Grading and Erosion Control Plan_V1.pdf Markup Summary

Project information block containing: FOX RUN SUBSTATION, EROSION CONTROL PLAN NOTES, TRI-STATE GENERATION & TRANSMISSION ASSOCIATION, INCORPORATED, 1100 W. 116th Ave., P.O. Box 33693, Denver, Colorado 80233, 303-452-6111, Date: 12/16/21, and drawing title: Reference Drawings.

59088-A-01-016

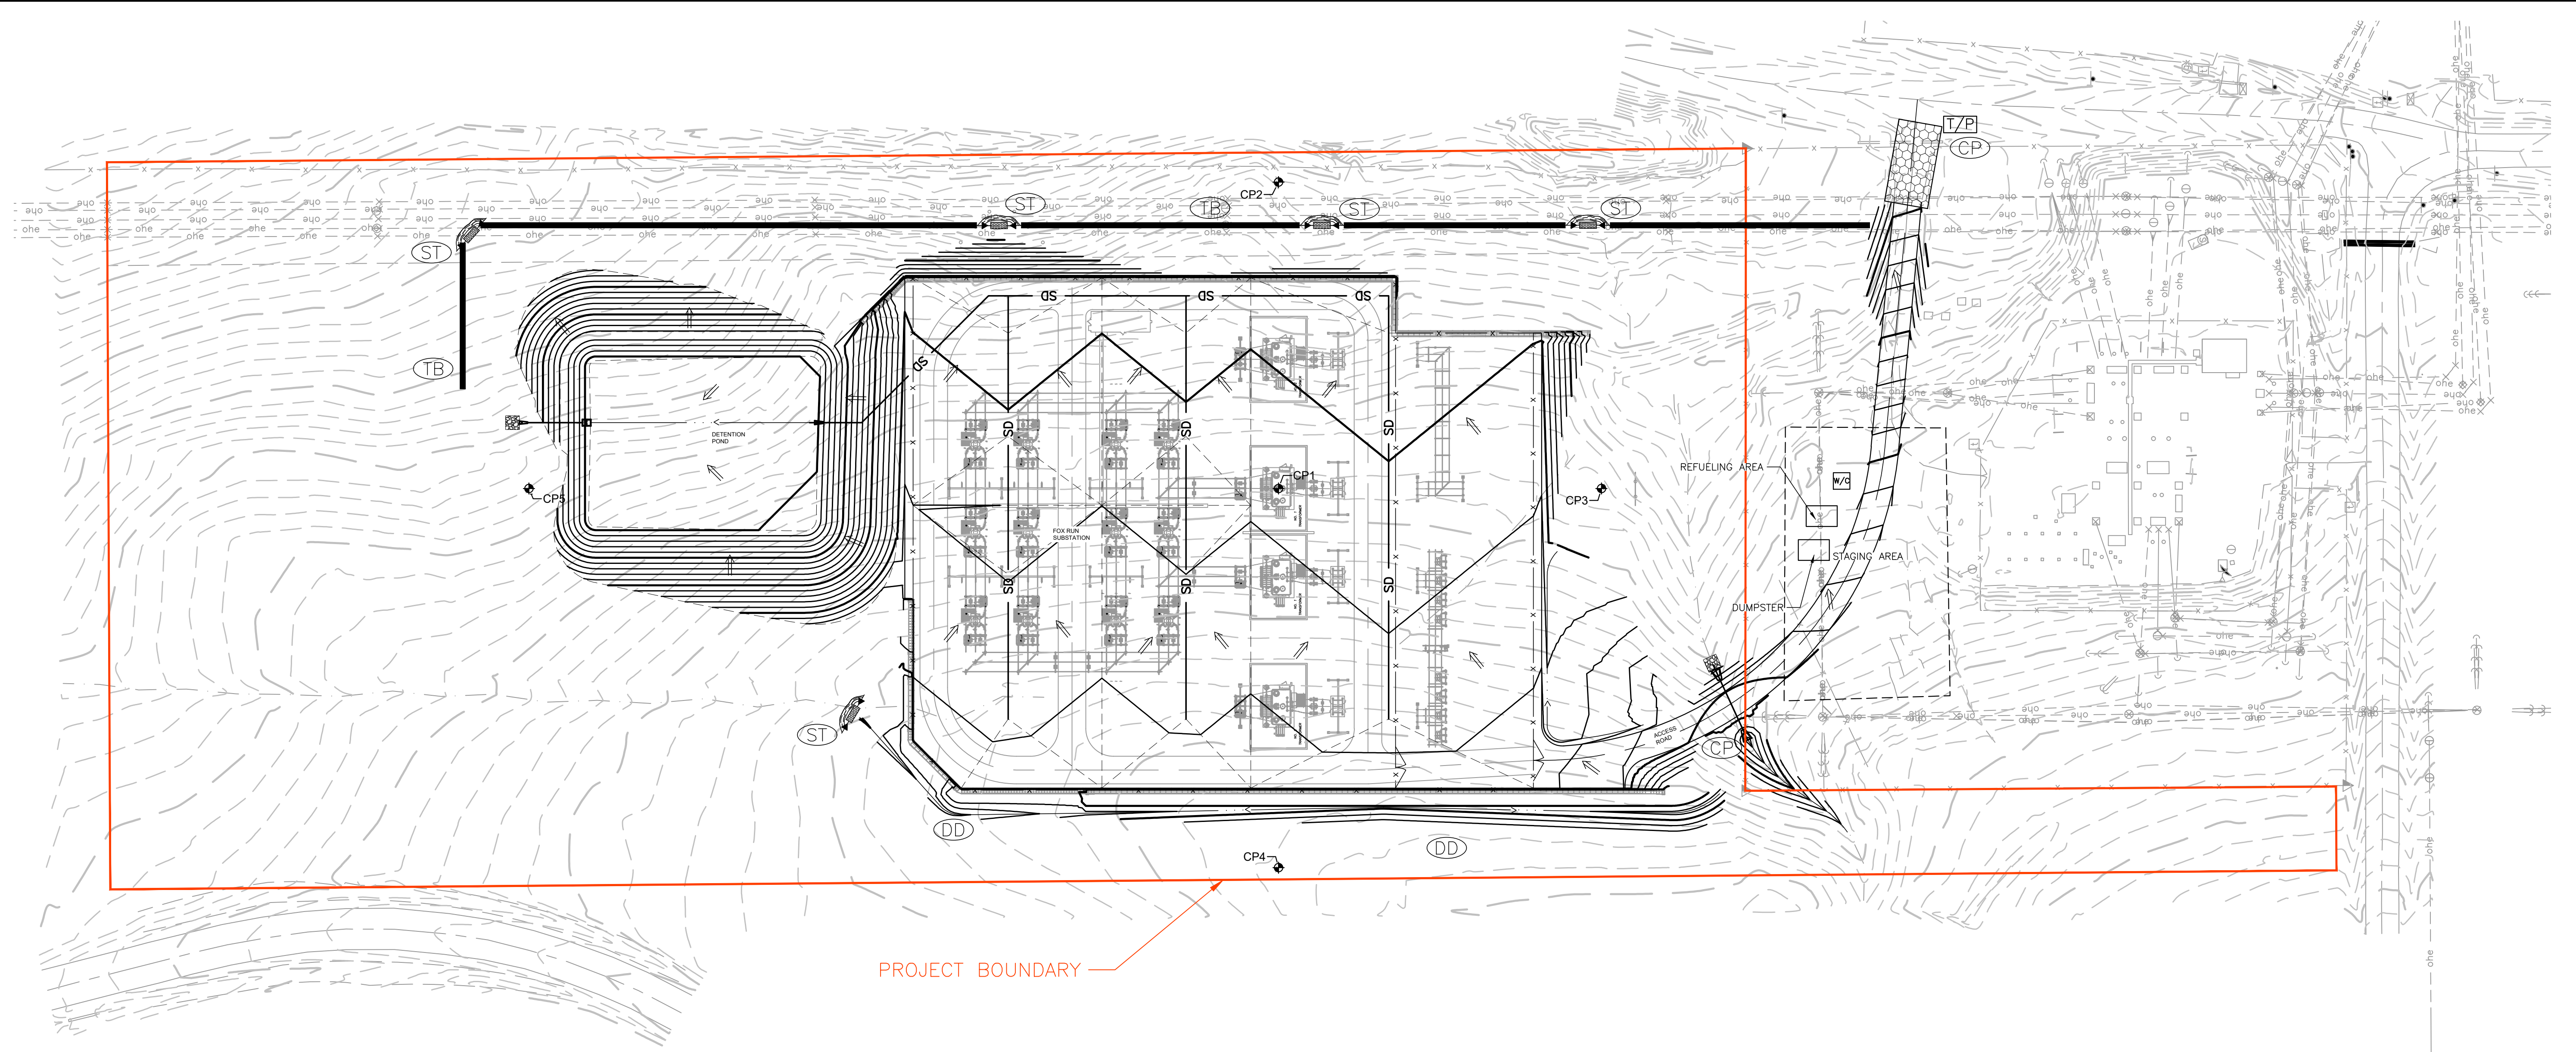
Add missing County Engineer Statement

Add sheet index and Point of contacts.

Add PCD File No. PPR2244

Add parcel #s

show all areas of cut/fill

S9088-A-01-018

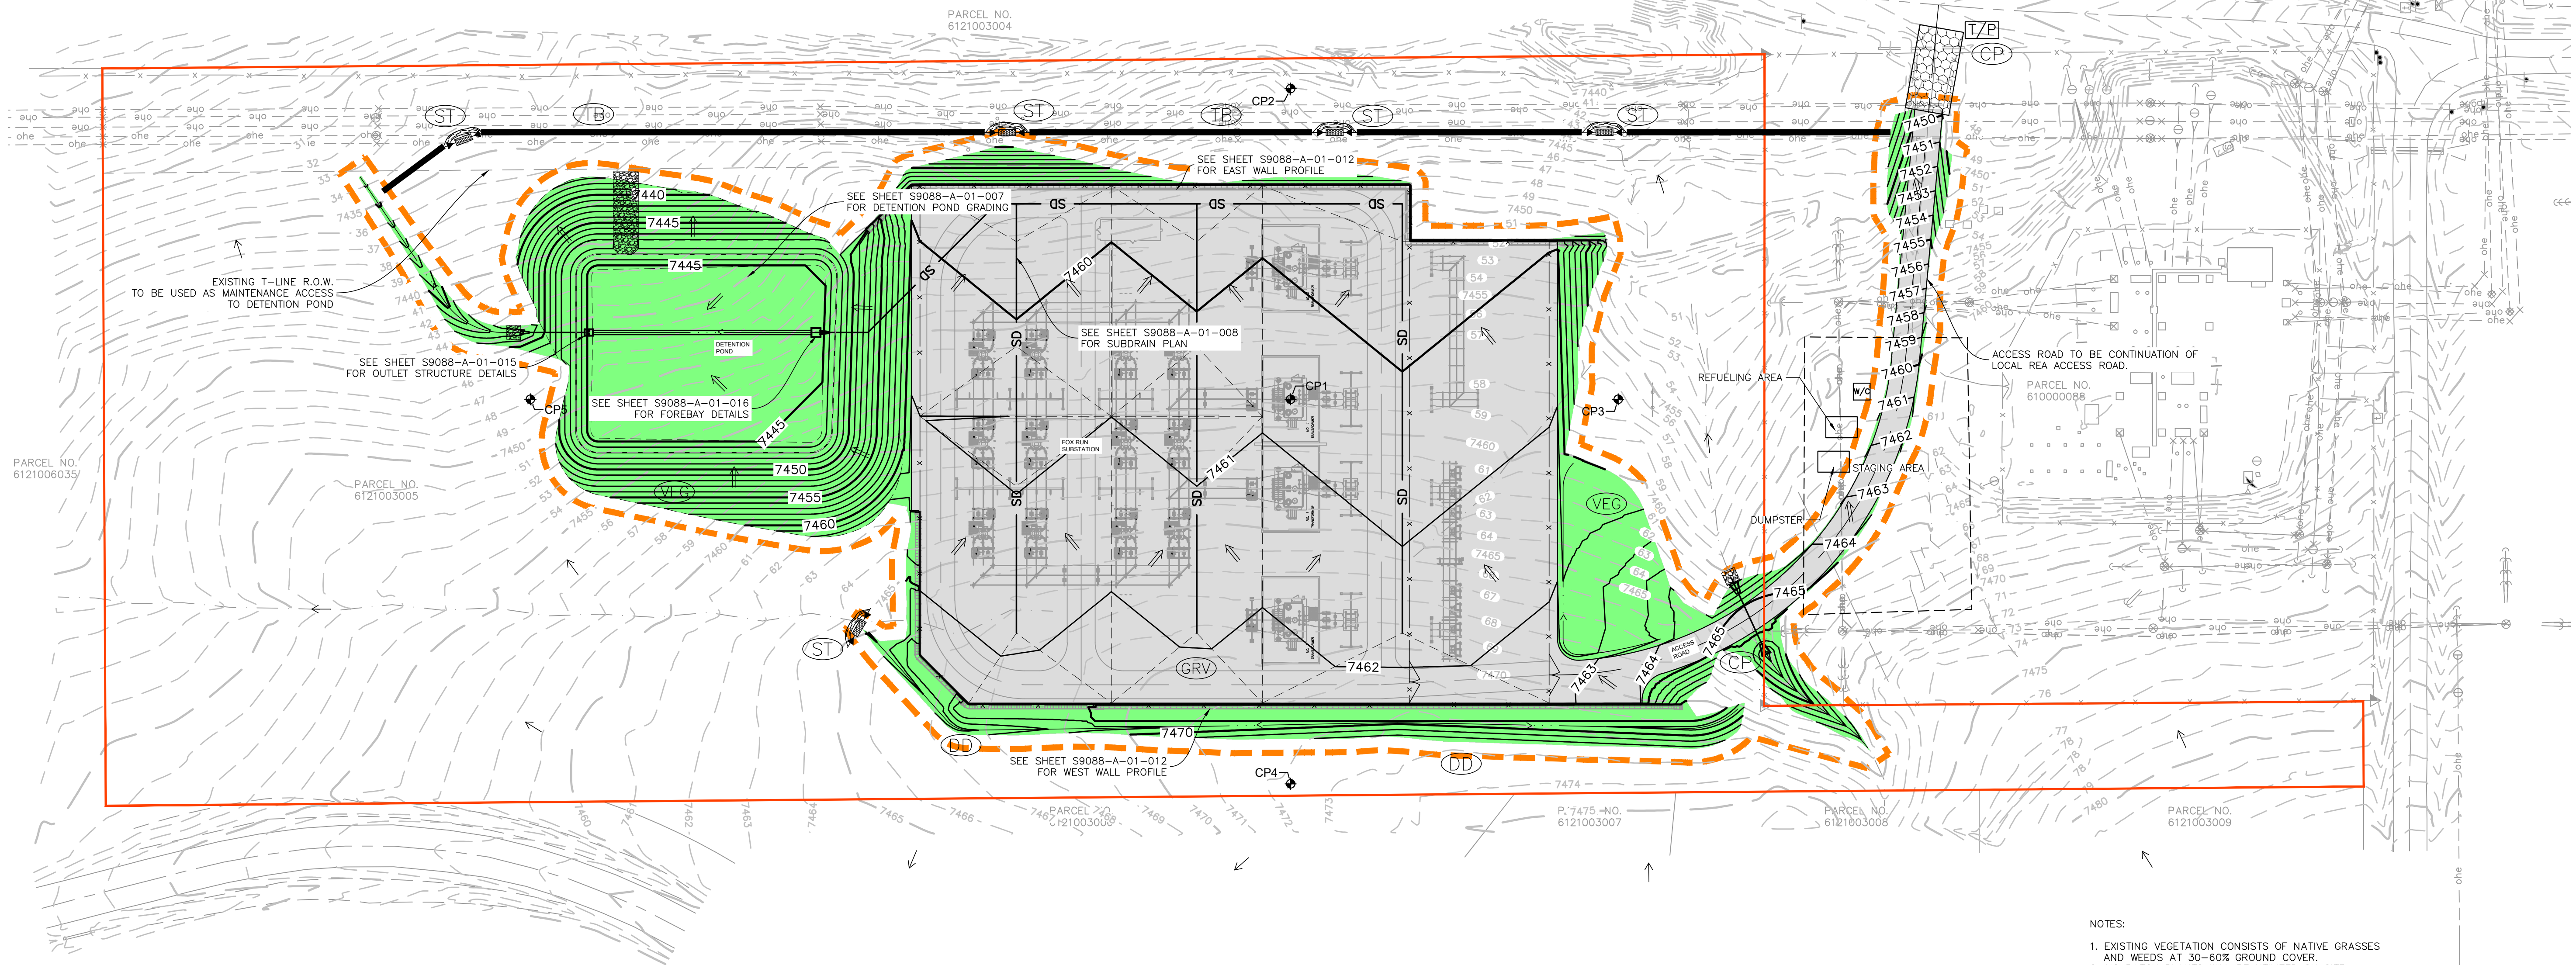
Denote wall heights

Provide details on depression area and if this area will be graded level

Provide details on inlets or show in design

Provide calculations and sizing

Show emergency spillway and overflow path.

Provide design details

Provide elevations-missing

Provide WQCV Detention Pond construction drawings to include outlet structure. orifice plate etc.

Add temporary and permanent BMP details

call out pond embankment erosion protection measure or material

Add all pertinent flow arrows

label adjacent properties

define line type in legend. Please show the following
1. property boundary
2. construction boundary, and
3. limits of construction

Label all proposed temporary construction BMPs by phase of implementation (initial, interim, final).

please show a detail/cross section of the drainage ditch

label contours

show all permanent stabilization (permanent seeding, gravel, asphalt, etc.)

show all pond maintenance easements and drainage easements

include all existing flow arrows and offsite flow arrows

add existing and proposed flow arrows to legend

show slope of pond walls

provide pond details for the forebay, trickle channel, outlet structure, trash rack, orifice plate, spillway, outlet protection (including riprap gradation), maintenance road,

Please include a note about the existing vegetation

To comply with the SWMP Checklist Item 17f, please add a note stating no batch plants will be utilized onsite.

This area is treating a lot of disturbance during construction and will retain water prior to installing the outlet structure. Suggest using it as a temporary sediment basin before converting it into an EDB in order to maintain compliance with CO water rights. (provide TSB details)

call out any offsite grading
